RZ-15-00001  
BIG CREEK TRAILS PUD  
Concerning Big Creek Trails PUD

Illustrative Master Plan
Big Creek
 A Planned Unit Development
 Kittitas County, Washington

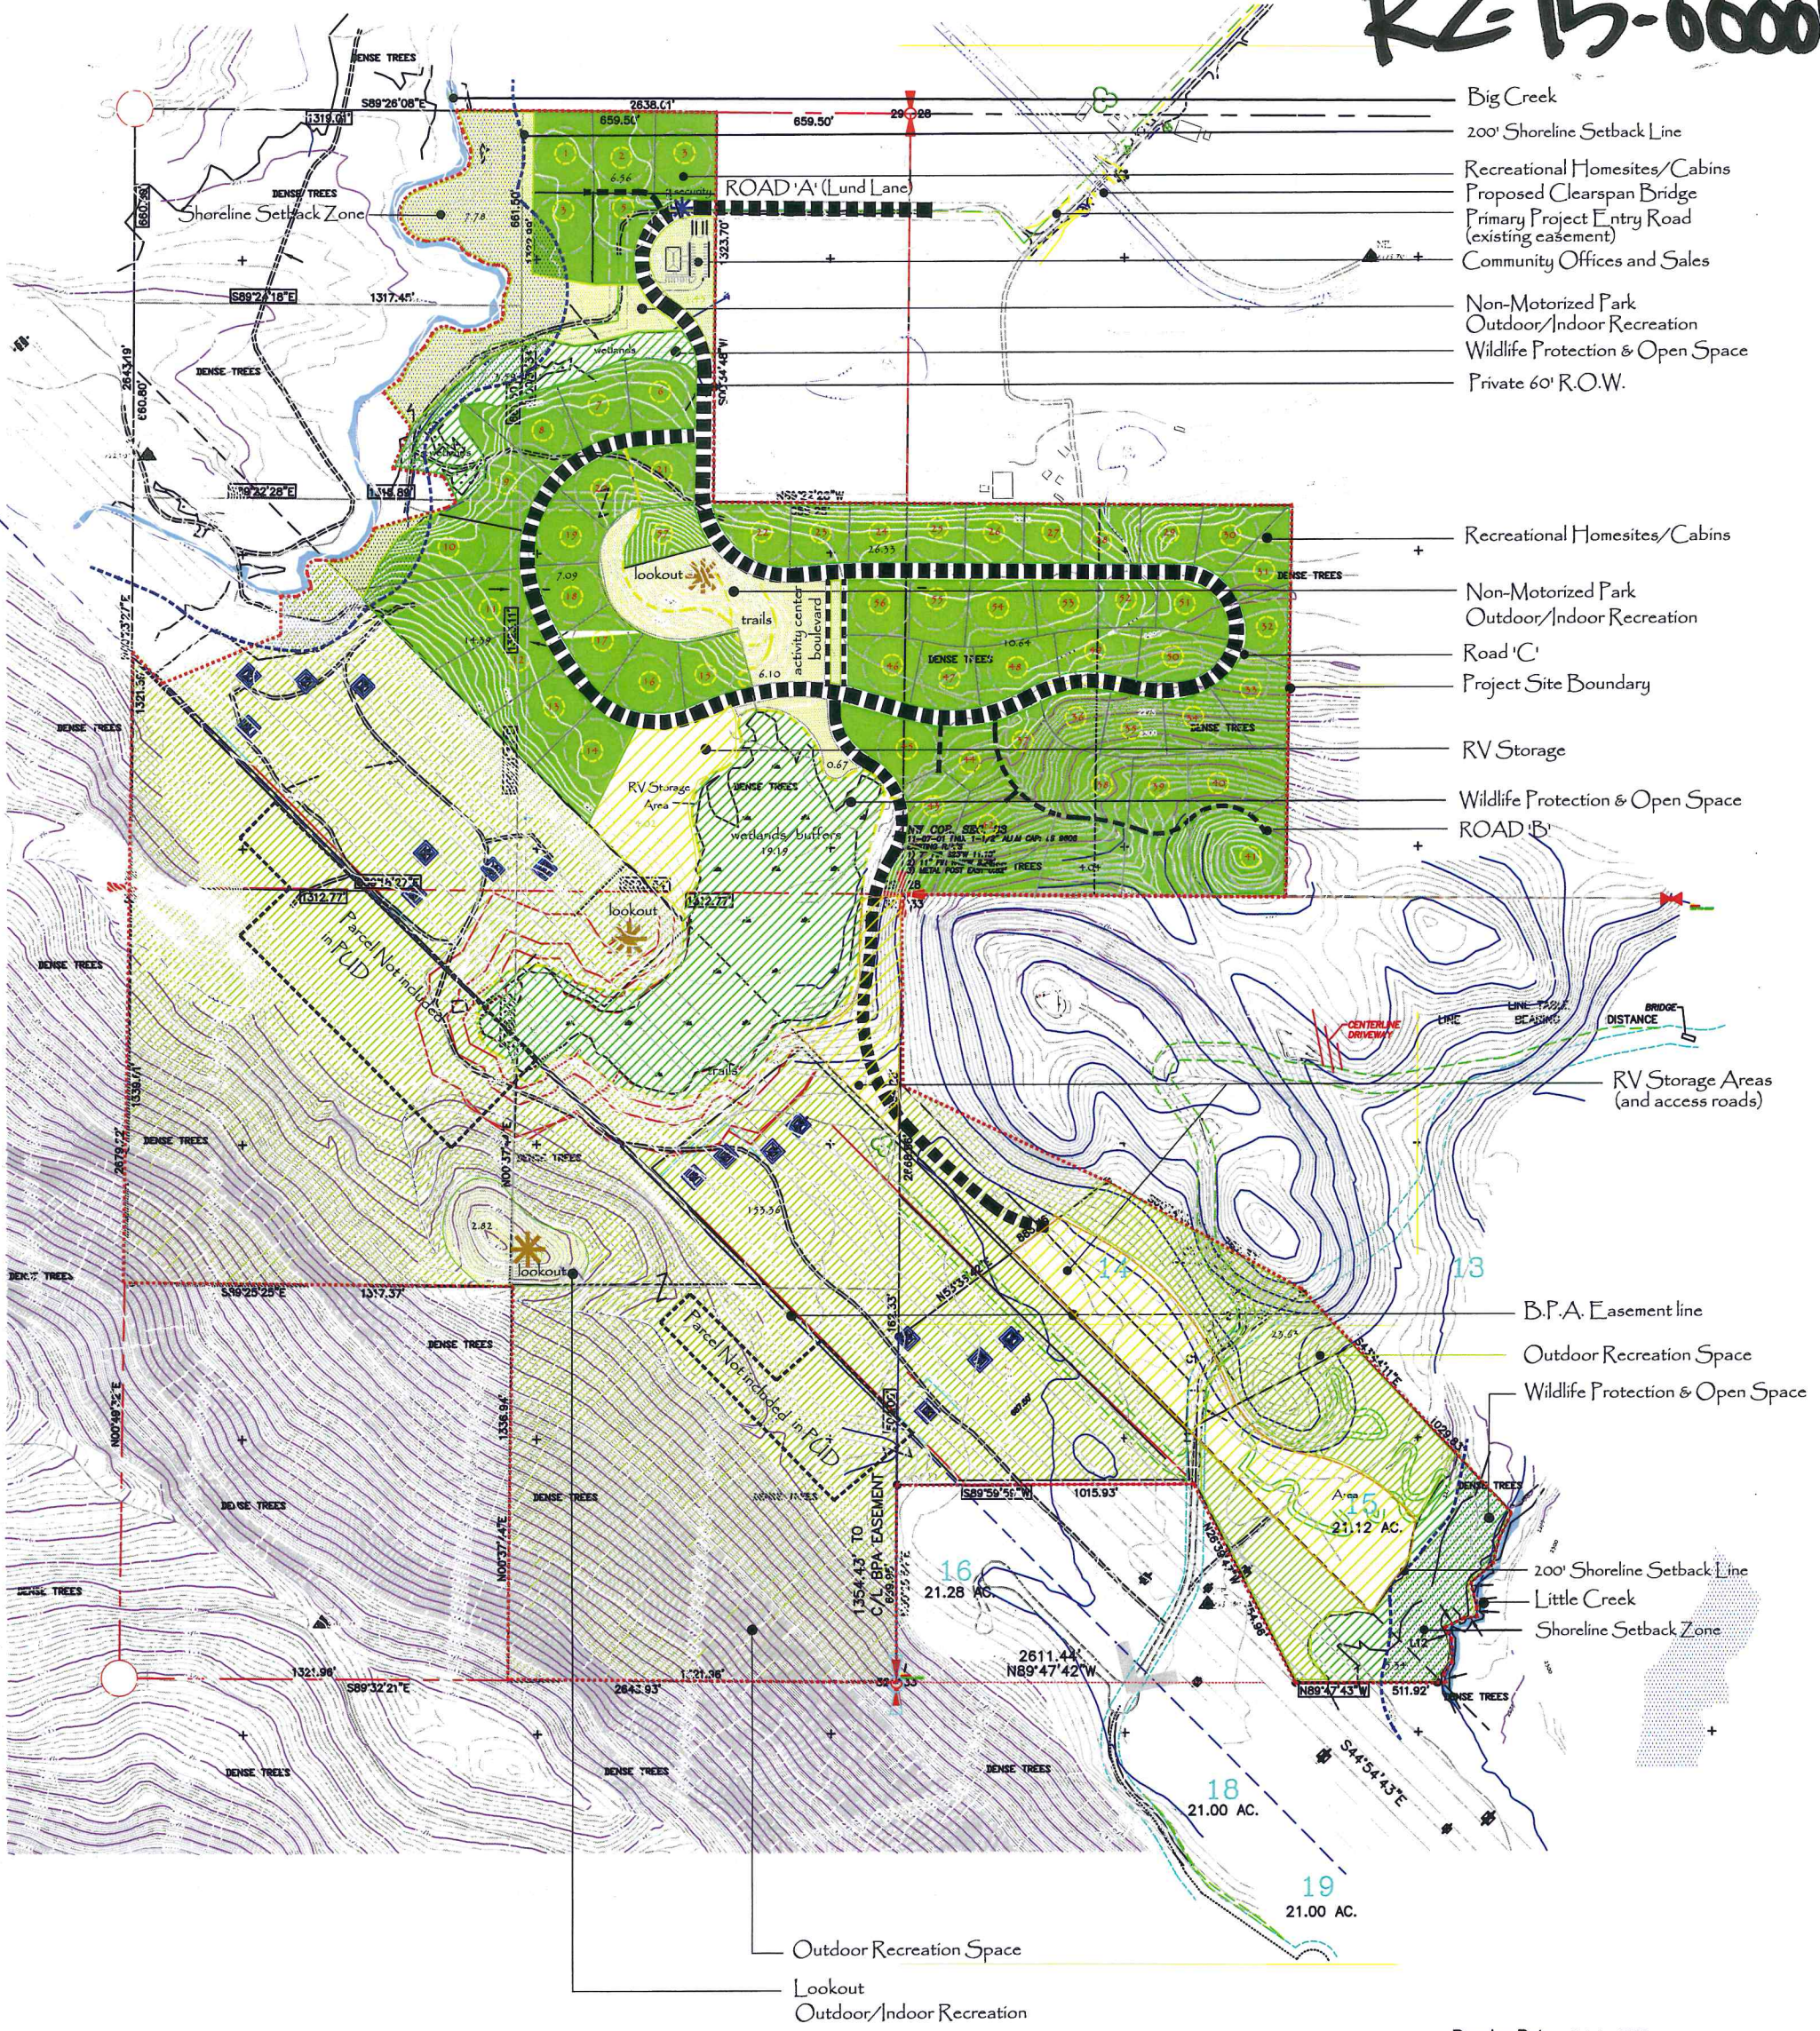
Also the set back from Ranch Property looks to be only 25 feet . This is not the city and we really do not want to see our neighbors. The feel and open look of nature is what our campers come to enjoy. Not a small city for profit. BIG CREEK TRAILS PUD have hundreds of acres. Please put a barrier/ green belt so we and our guest can enjoy the country not the city feel of the area. This housing development really does not fit in this area. Too many houses stuffed into not enough land . Reduce the amount of houses . It should be 5 acres to 1 house as zoning intended. What next apartments ?
